From: Simon Davis
Sent: 31 October 2019 12:19
To: 'Rebecca Redford' [REDACTED]
Subject: RE: Yapton Metal Company - refs Y/42/19/DOC and Y/61/19/PL

Site Plan (Proposed) 1:200

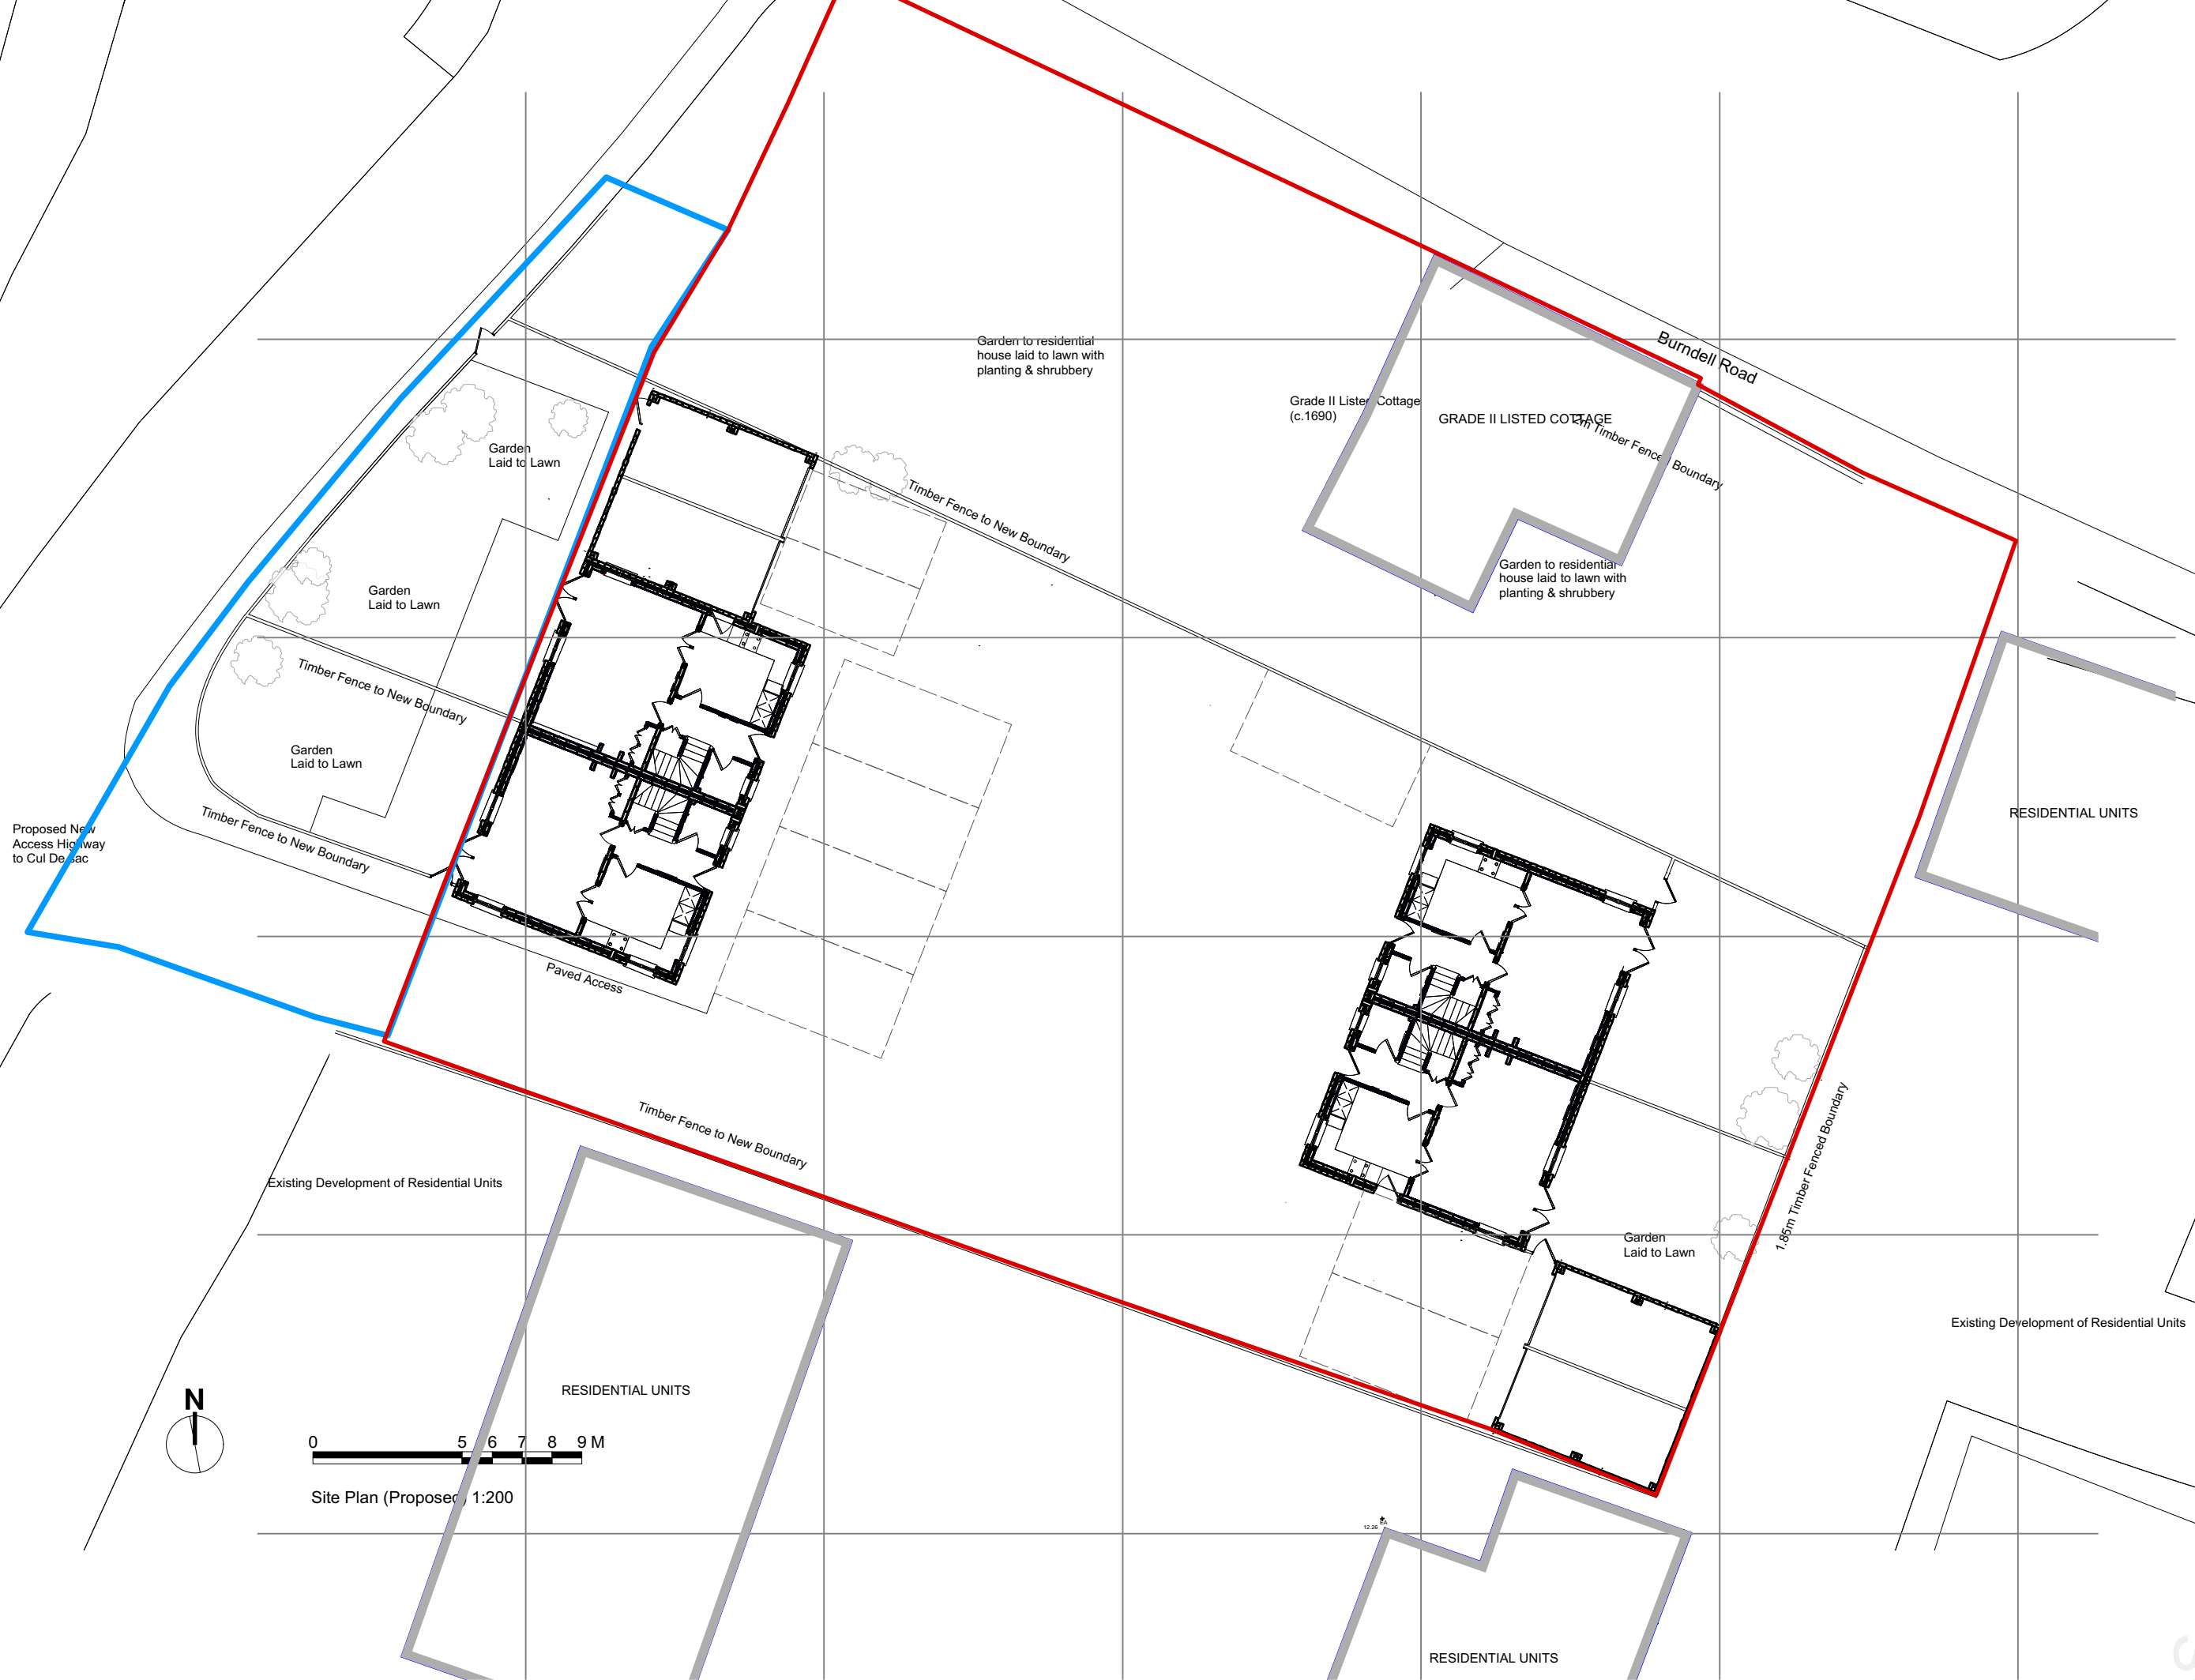
FYI, I started work on my report yesterday. On the matter of the materials and windows/doors, I do not see how I can discharge the relevant conditions under this variation application and you will therefore need to submit a separate application to discharge the conditions which are worded pre Damp Proof Course (nos. 8, 9 & 10 of Y/53/16/PL).

The amended plan as you requested and the area has been calculated 0.19ha.
